DOC 18/707077-1
MP 09_0175 MOD 2

OEH Review of Environmental Assessment: Karuah East Quarry Project Modification 2 (MP 09_0175) – Mid Coast LGA

Karuah East Quarry Project Modification 2 (MP 09_0175)

Figure 7: Vegetation Communities and Survey Effort.

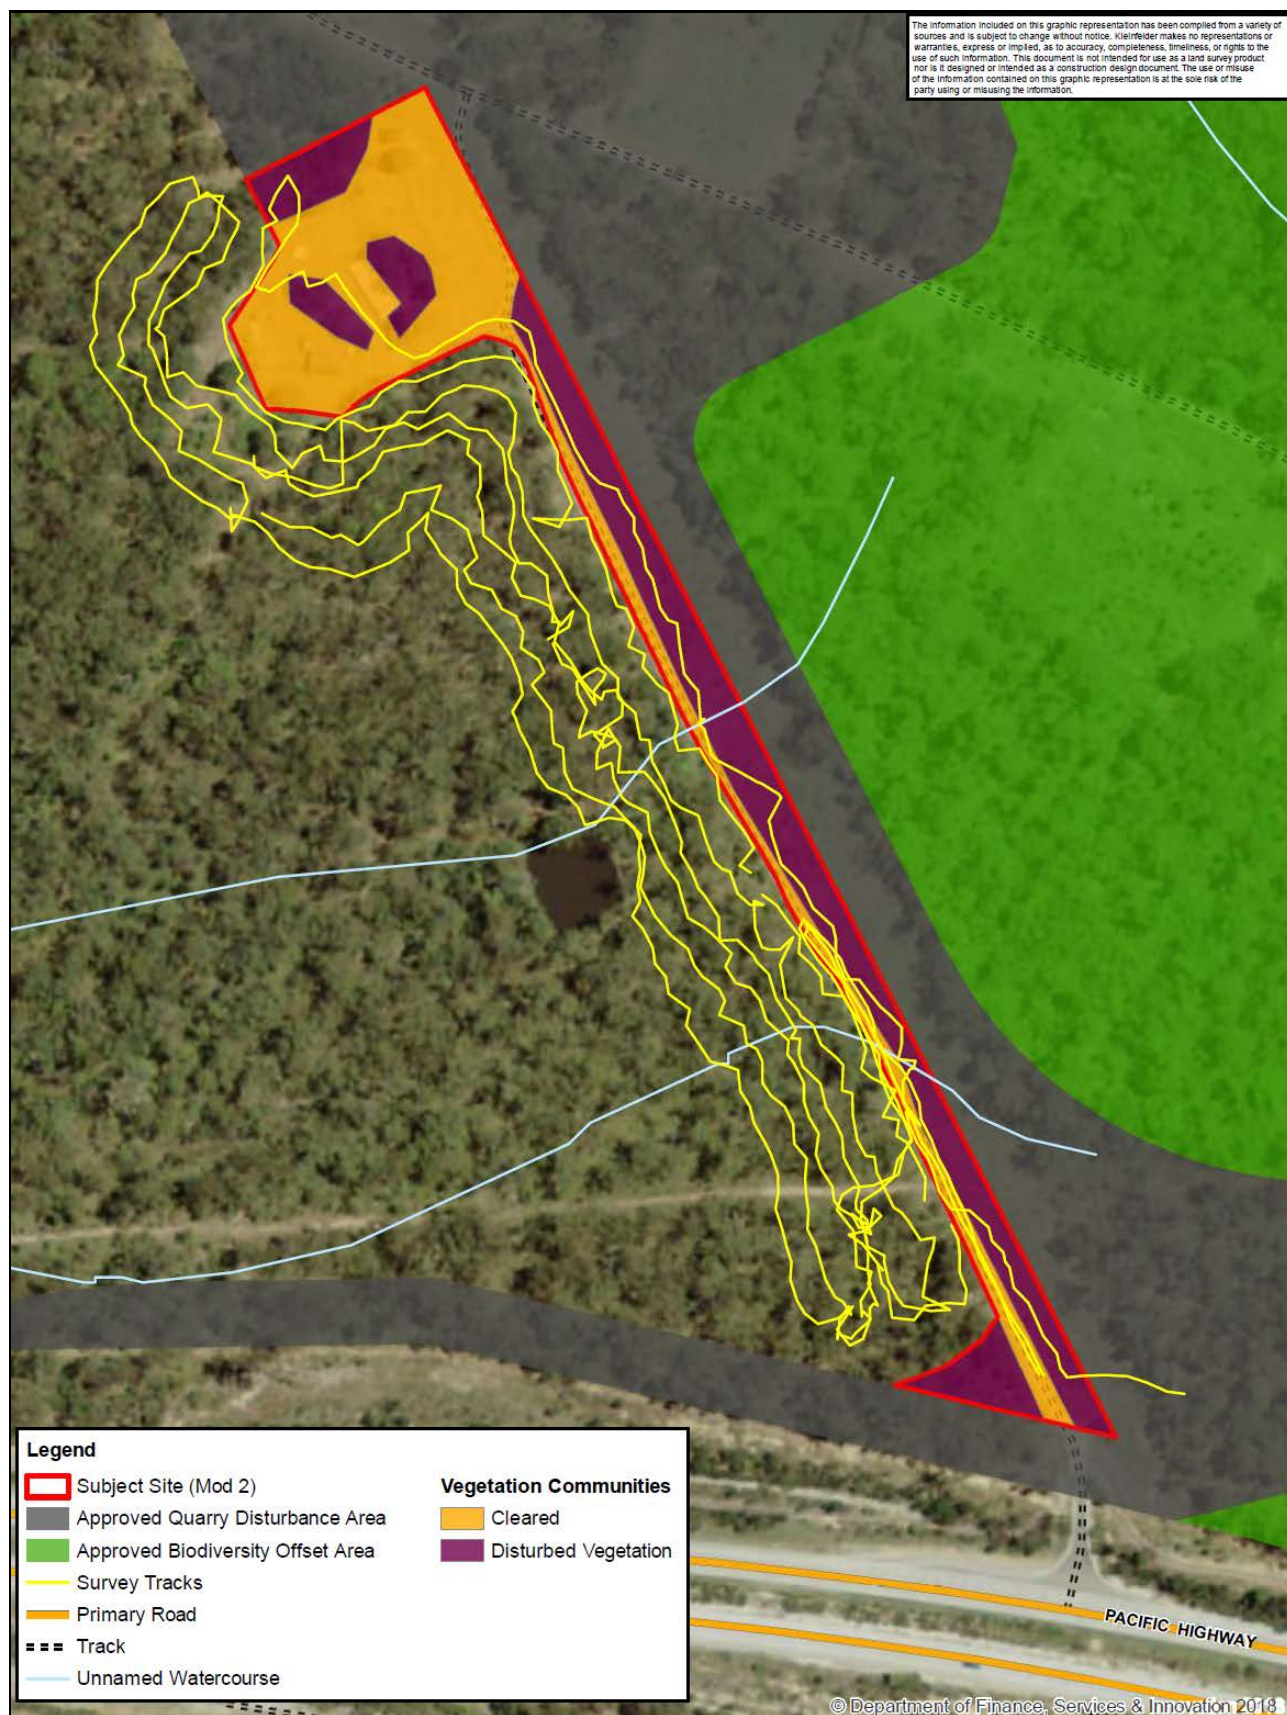
The modification proposal impacts on approximately 0.57 hectares of vegetation, which is described as disturbed or managed vegetation. The vegetation does not match a Plant Community Type under the Biodiversity Assessment Method. OEH concurs that the vegetation description provided in Section 3.2.2 of Appendix C represents highly disturbed vegetation which is of limited habitat value.

No threatened species (apart from a planted *Macadamia integrifolia*) were identified for the site and the site was deemed to be of limited habitat value. *Macadamia integrifolia* (Macadamia Nut), which is listed as vulnerable under both the BC Act and the *Environment Protection and Biodiversity Conservation Act 1999* were detected within the subject site, however it is noted that they were planted as a garden feature near the existing dwelling. They do not naturally occur within the subject site. As such, OEH concurs that no further assessment is required on this species.

FIGURE 2: PROJECT AREA WITH AHIMS

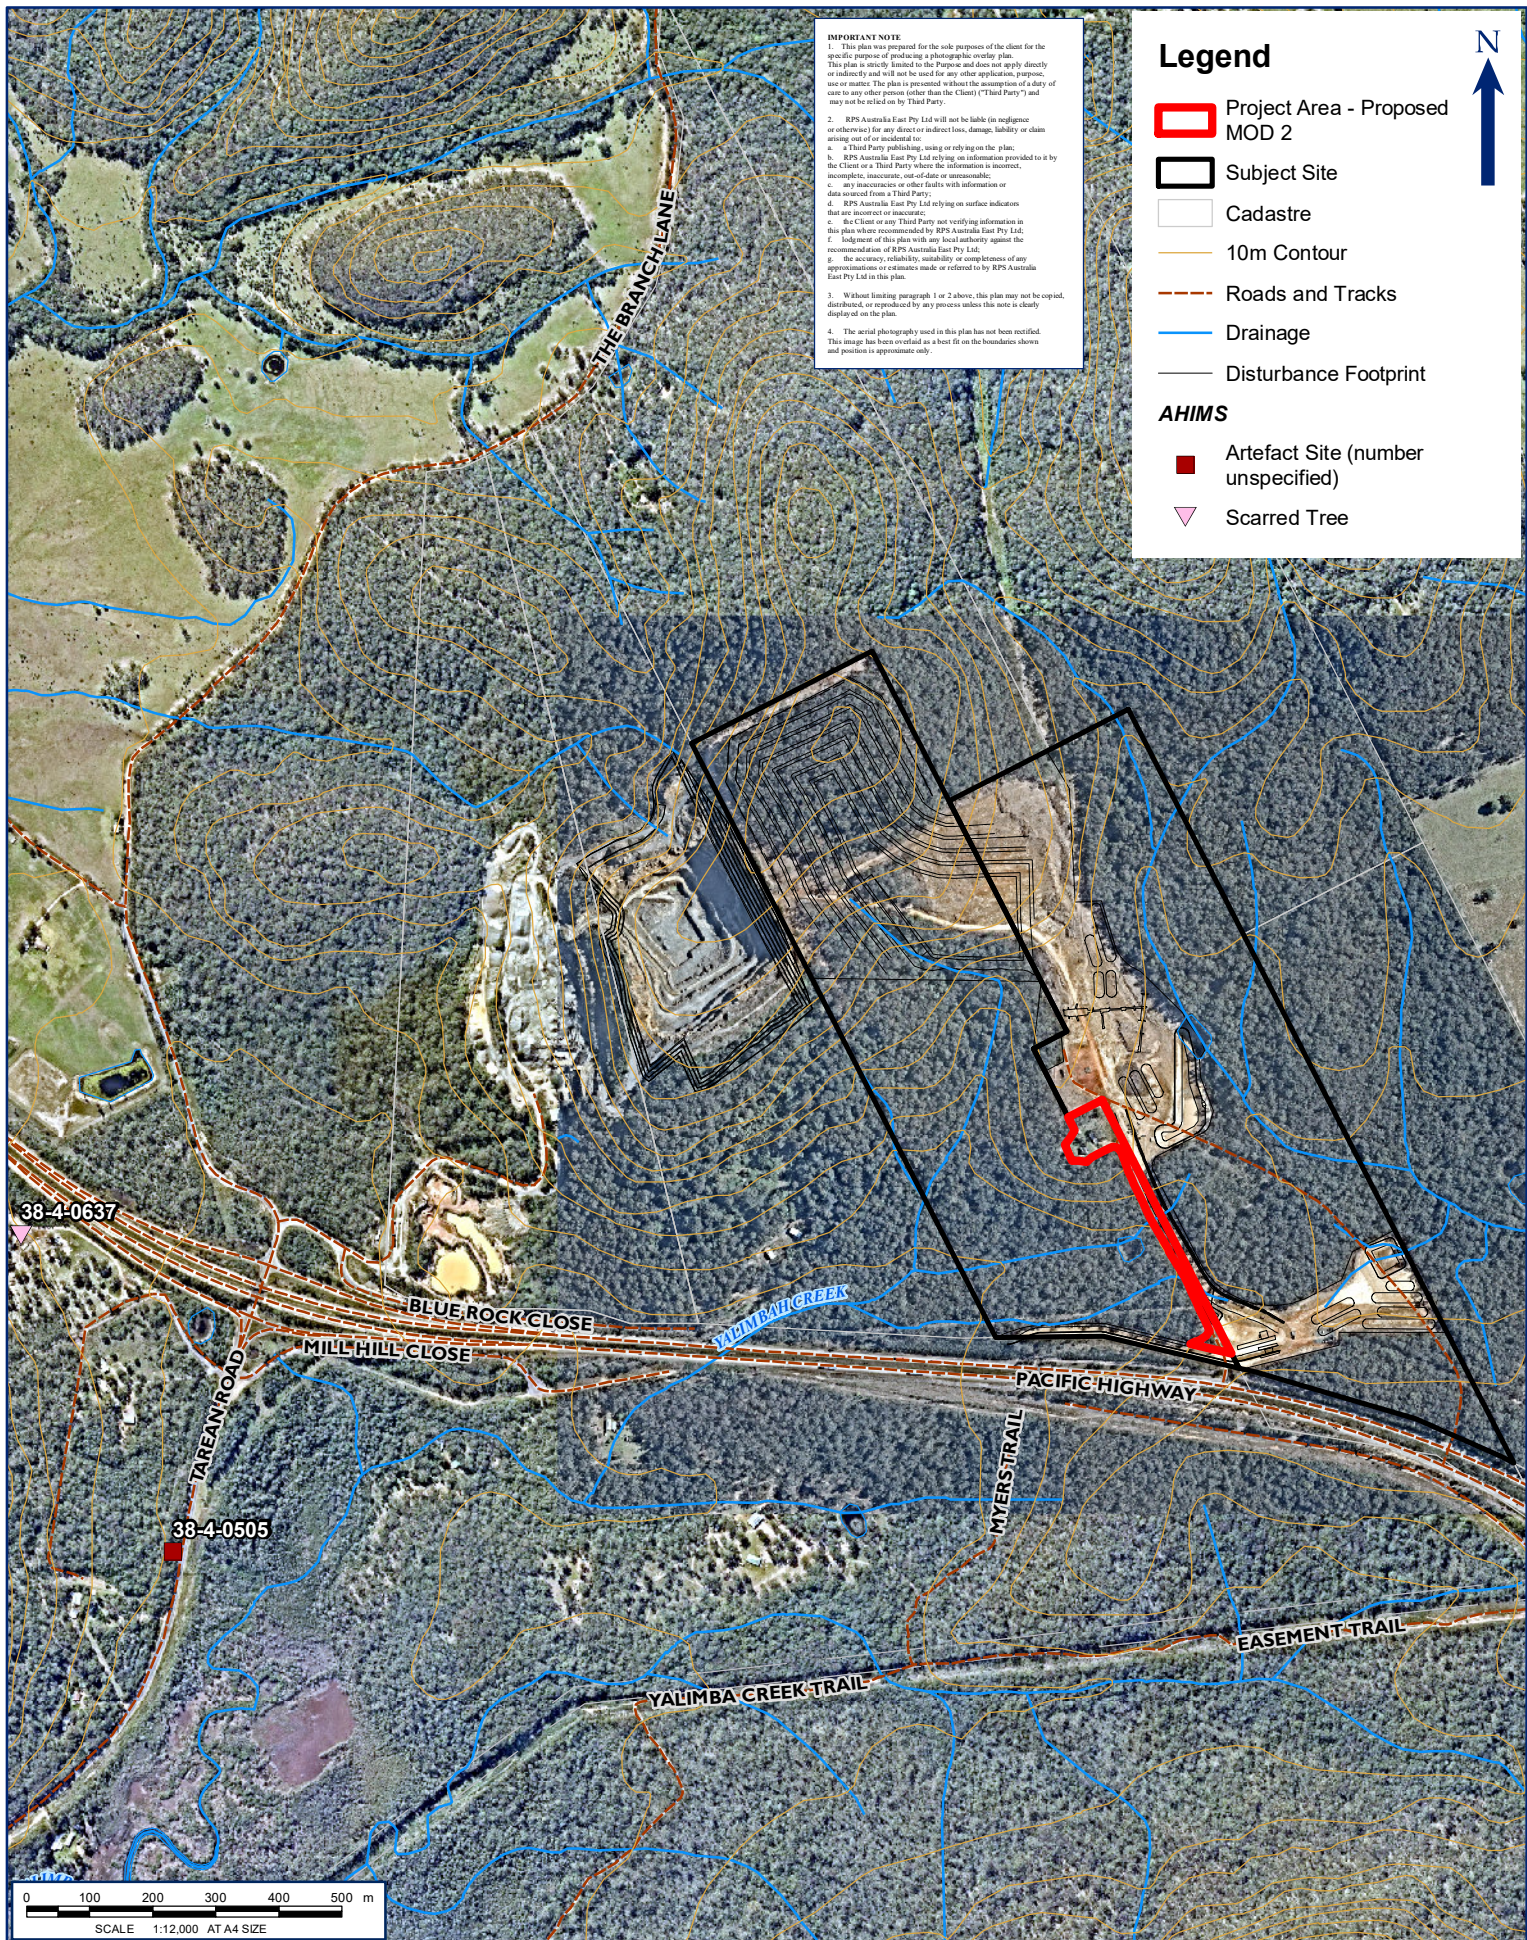
OEH is unable to comment on the adequacy of the assessment of impacts on Aboriginal cultural heritage based on the *Karuah East Quarry MOD2 Due Diligence Report* (RPS 2018) as OEH does not review Aboriginal cultural heritage due diligence reports. Based on the information supplied, OEH is unable to determine if there are any Aboriginal cultural heritage values present within the Karuah East Quarry MOD 2 boundary.

There is a risk that Aboriginal cultural heritage values may be present in the modification area as the proponent intends to undertake the modification in accordance with a due diligence assessment rather than preparing an Aboriginal cultural heritage assessment report for the modification.

The proponent should consider the risk associated with undertaking the modification under a due diligence assessment and without preparing an Aboriginal cultural heritage assessment report.
